2025/0807

166 Barnsley Road, Darfield, Barnsley, S73 9DQ

**Change of use to a seven-person house in multiple occupation (HMO)
(Retrospective)**

PLANNING
 PROPOSED
 PLANS AND ELEVATIONS

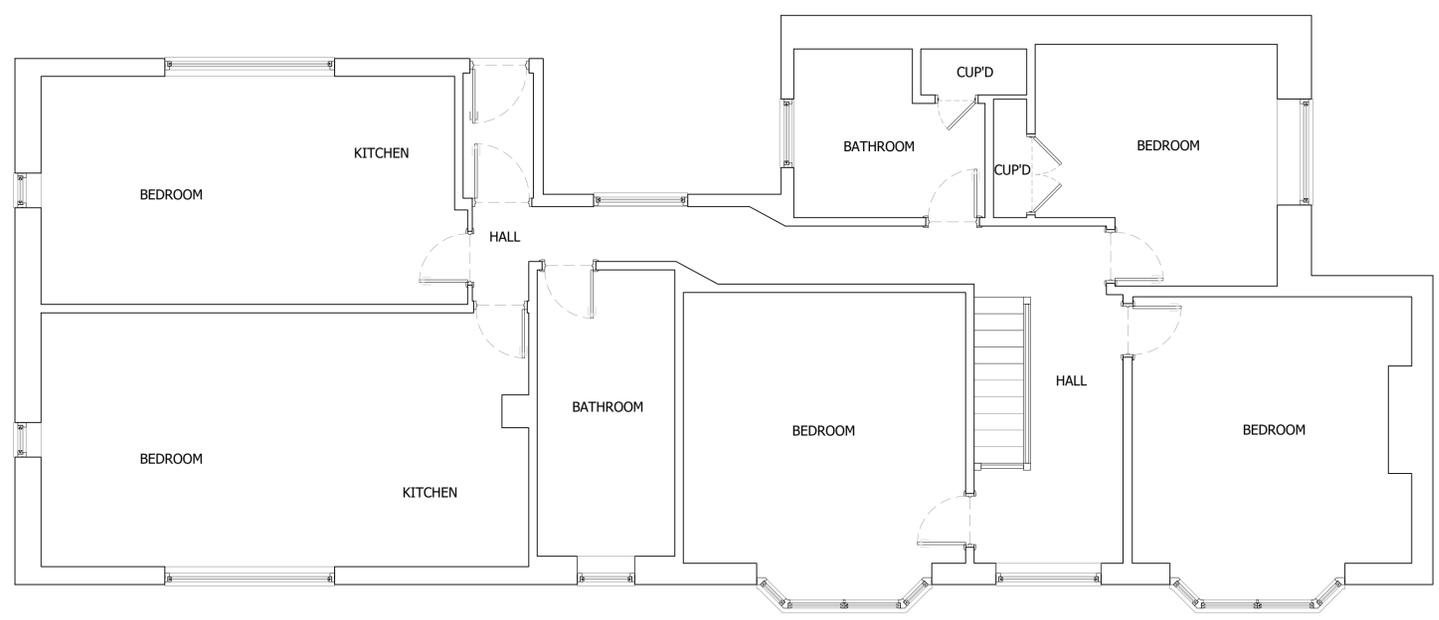
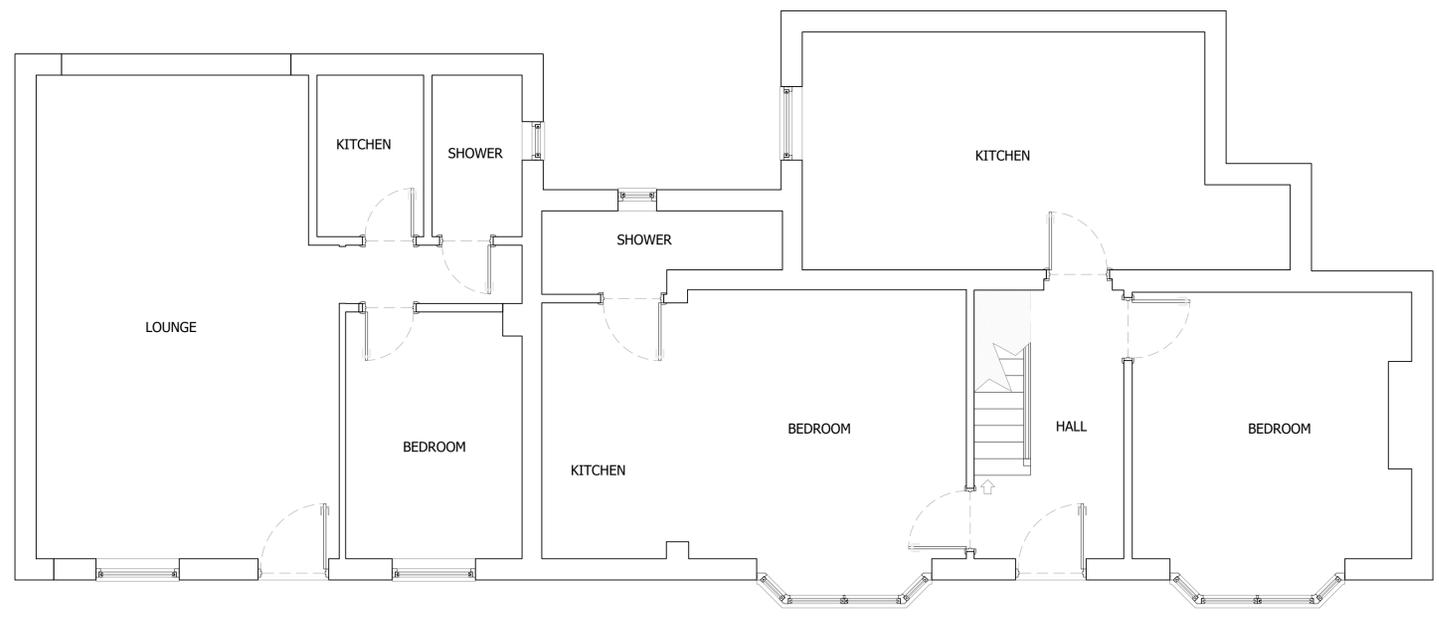
The applicant hasn't labelled each of the rooms, but the planning statement states that the occupants would be sharing amenities. The LPA can only assess what has been submitted. It should also be noted that the applicant has not provided communal living space for the possible occupants. The plans show from left to right:

There are then 2 bathrooms on the first floor which is presumed to be communal bathrooms along with a kitchen on the ground floor for the use of flats 3 – 7 and the kitchen on the ground floor would also be used for these flats.

should be noted that the LPA cannot control how many occupants will be living in each of the rooms. It is not controllable who would be renting the rooms and as such it should be considered that couples could be living in the property. As such each room would be required to meet the double bedroom standards. Flats 1 and 6 would not meet these double bed standards, but would meet the single standards, but as explained above it is not controllable how many occupants would be staying in each bedroom. The applicant has also not labelled the intended occupancy of each bedroom.

The South Yorkshire Design Guide also states that the minimum bathroom size should be 3.5sqm, the proposed communal bathrooms exceed these requirements. The SYDG also states that the applicant should provide communal living areas for the occupants. This has not been provided by the applicants and has not been labelled on the plans and as such the occupants of flats 2 -7 would be confined to the shared kitchen, bathrooms and their bedrooms without any communal living space.

The SPD also goes on to state that the external amenity space should be at least 60m². The proposed site plan shows no private amenity space to the rear and as such would not provide occupants with any private space. The amenity space which once occupied the rear of the site has been replaced with the convenience store which is connected to the dwelling.

The application has been assessed by the Council's Transportation Officer, and they have stated that the plans submitted by the applicant are unclear, as they do not show how many parking spaces can be accommodated within the site. In accordance with Barnsley's Parking Standards, a minimum of 4 spaces should be provided for a HMO of this size and given the location, it is essential that these parked vehicles can be managed to turn within the site as is the existing situation due to the classification of Barnsley Road. Therefore, insufficient information has been provided in the form of parking spaces and swept paths to show it meets those requirements. Therefore the proposal would be in conflict with policy T4 of the Local Plan.
